**From:** Tim Townsend [REDACTED]  
**Sent:** 16 September 2015 10:59  
**To:** caroline.gould  
**Cc:** Neil Crowther; Harvey Rogers; Paul Davis; Adrian Barnley; Barry Smith  
**Subject:** RE: LU/114/15/RES - Approval of reserved matters following outline planning consent LU/47/11 for layout, appearance and landscaping of access road.

**Subject:** LU/114/15/RES - Approval of reserved matters following outline planning consent LU/47/11 for layout, appearance and landscaping of access road.

Drawing No.	CV8140927/600-1	Rev	P2
-------------	-----------------	-----	----

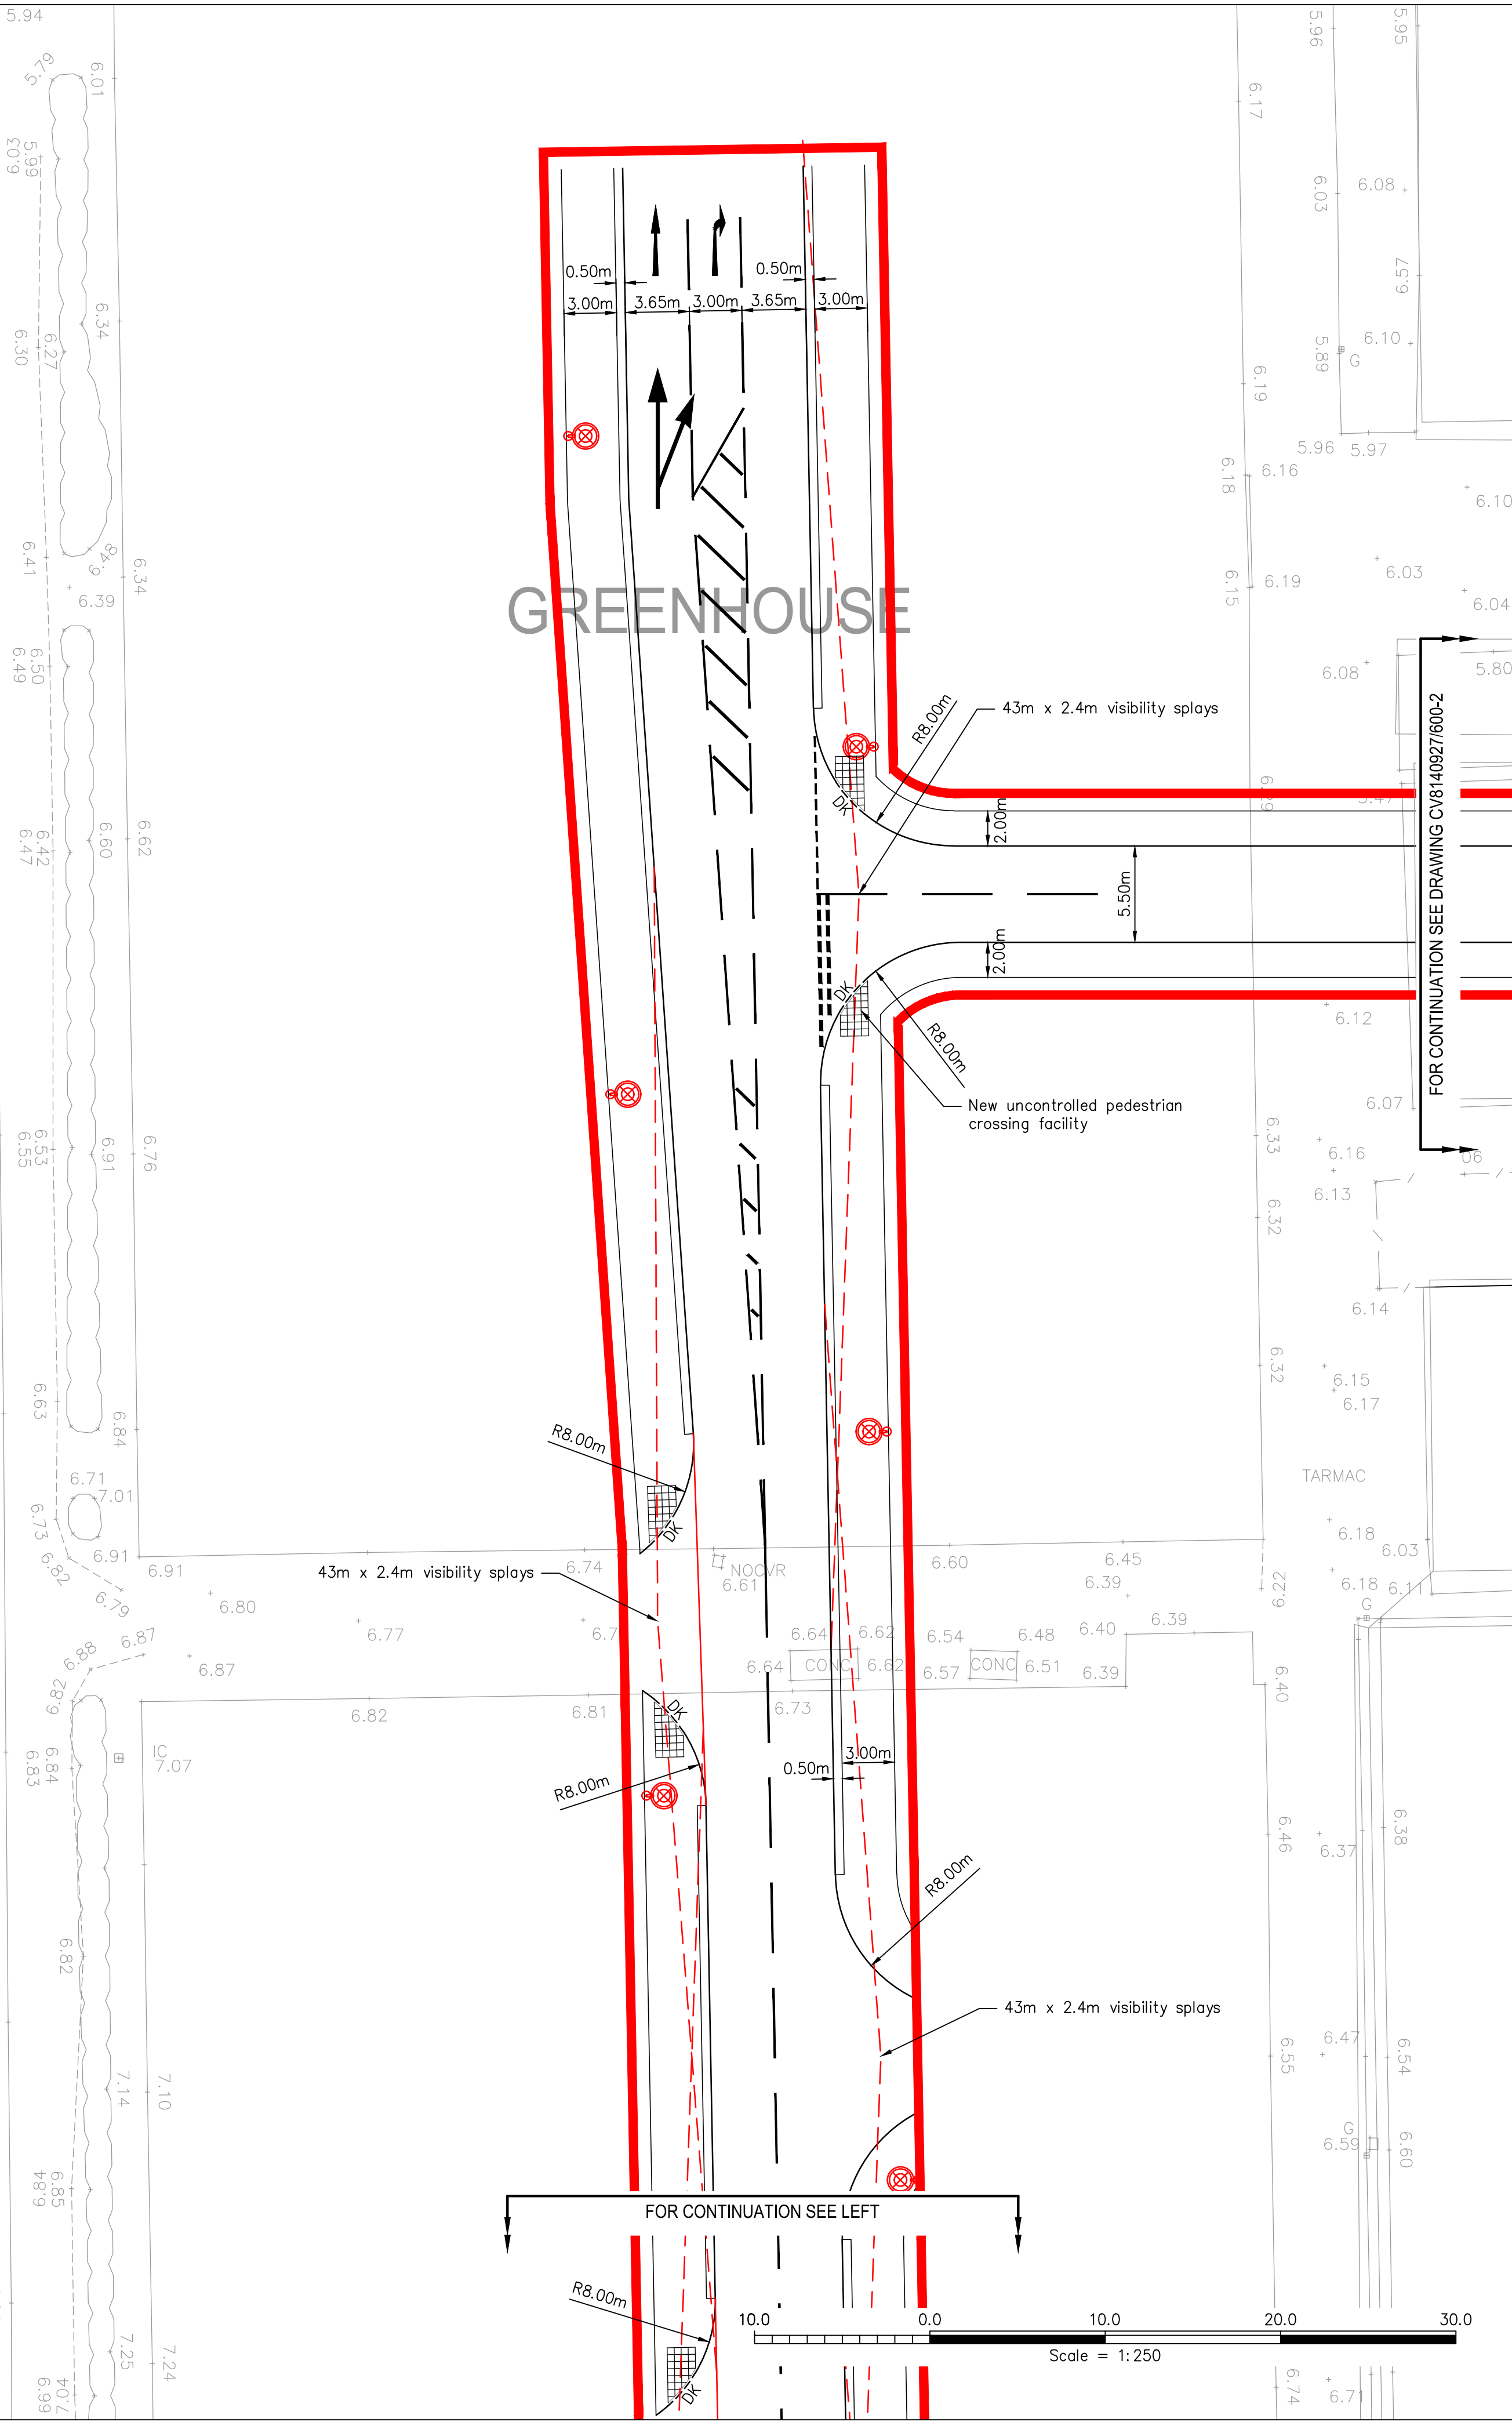
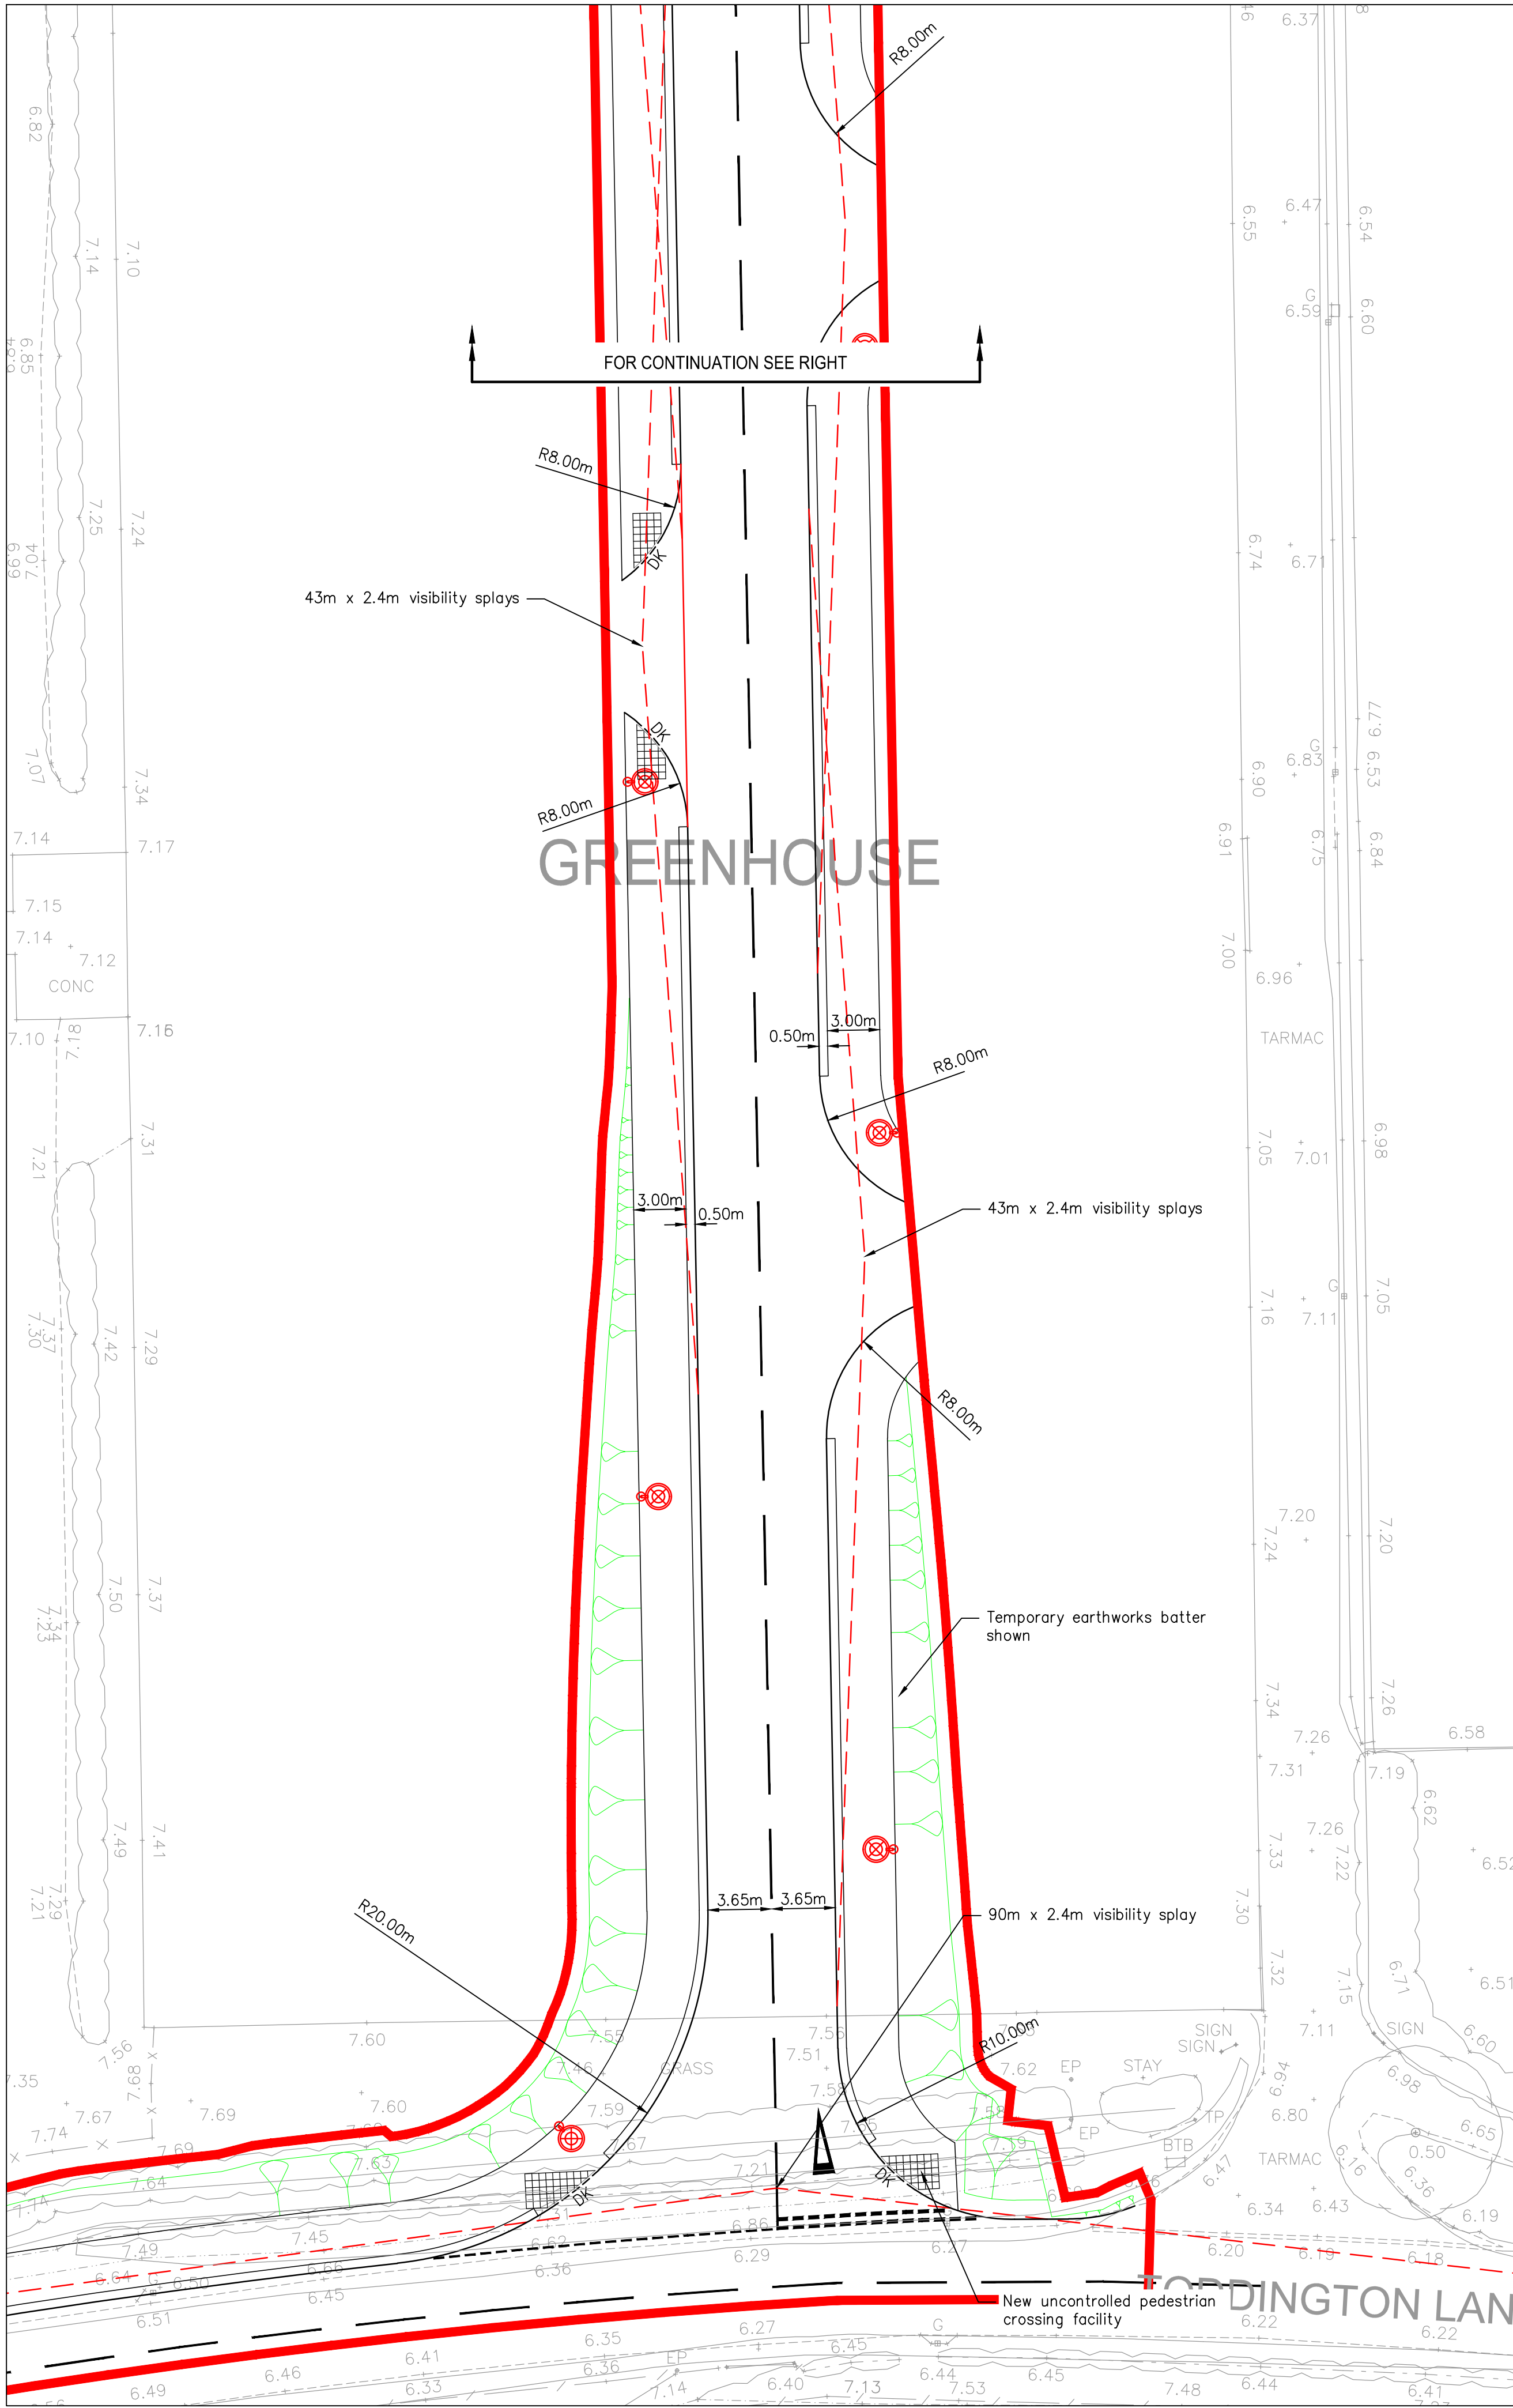
2. Bellmouth radius, west side of junction with Toddington Lane – Although the swept-path diagrams don't show every vehicle passing scenario, they do show that some HGVs will require a larger radius on the western side to avoid some conflicts. Notwithstanding any previous RSA review, if I am not to raise an objection on this occasion, I would expect the option to revisit the junction at a later date to be

4. Please provide the full extent of visibility splays at all junctions (including forward visibility splays – commensurate to pedestrians and, where they will be present, cyclists). A 4.5m 'x' distance should be shown at the junction of the north-south road with Toddington Lane. Noted. However, please provide a plan showing the full extent of the sight line splay in the trailing traffic direction (looking east) at the southern end of the access spine road with Toddington Lane. Also, the height of the road tables

5. The footway on the eastern side of the main north-south access road (southern end) should be extended eastwards and tactile paving provided to correspond with a crossing point on the south side of Toddington Lane. Pedestrian visibility should also be shown at this point. This has not been shown.

9. For 'crossroad' arrangements on east-west access road, these should be constructed as raised tables in accordance with WSCC standard details. As shown, the rumble strip details are unlikely to provide adequate speed control. Please show. Recommend height should be 75mm (or 0.075m). Please show on an amended plan.

Title :
Typical Raised Table Arrangement

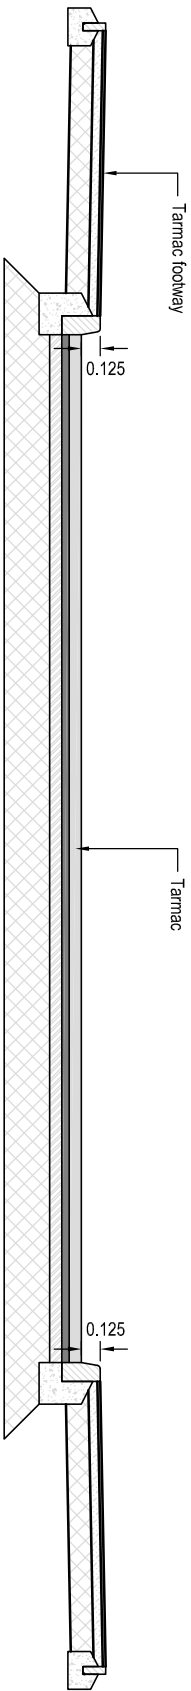
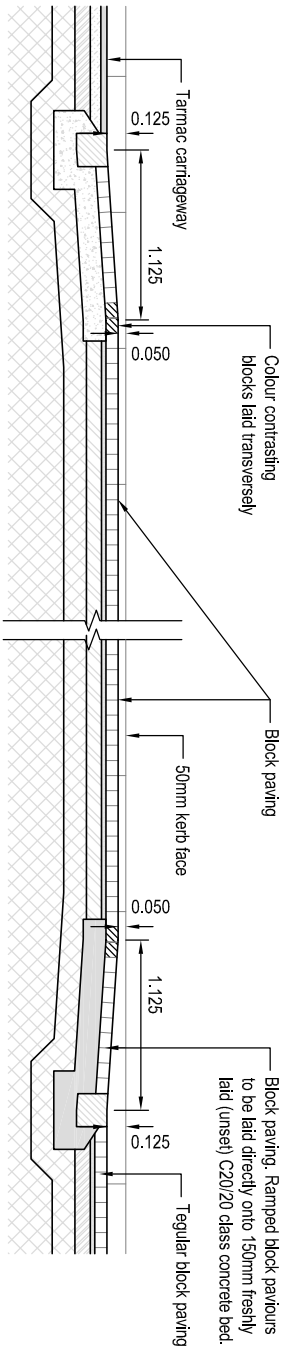
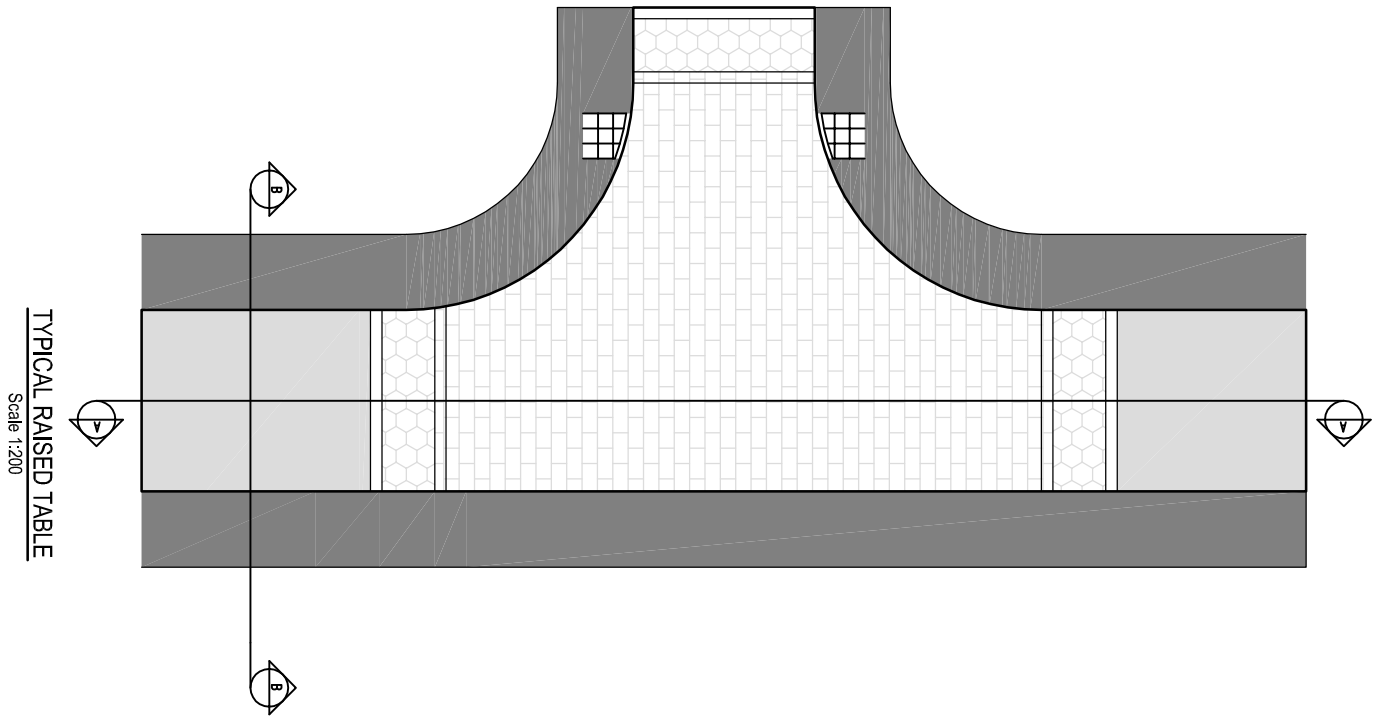
5. Raised tables – I have looked again at Drawing No. CV8140927/SK10 and can confirm that the table heights meet WSCC guidance at 75mm.
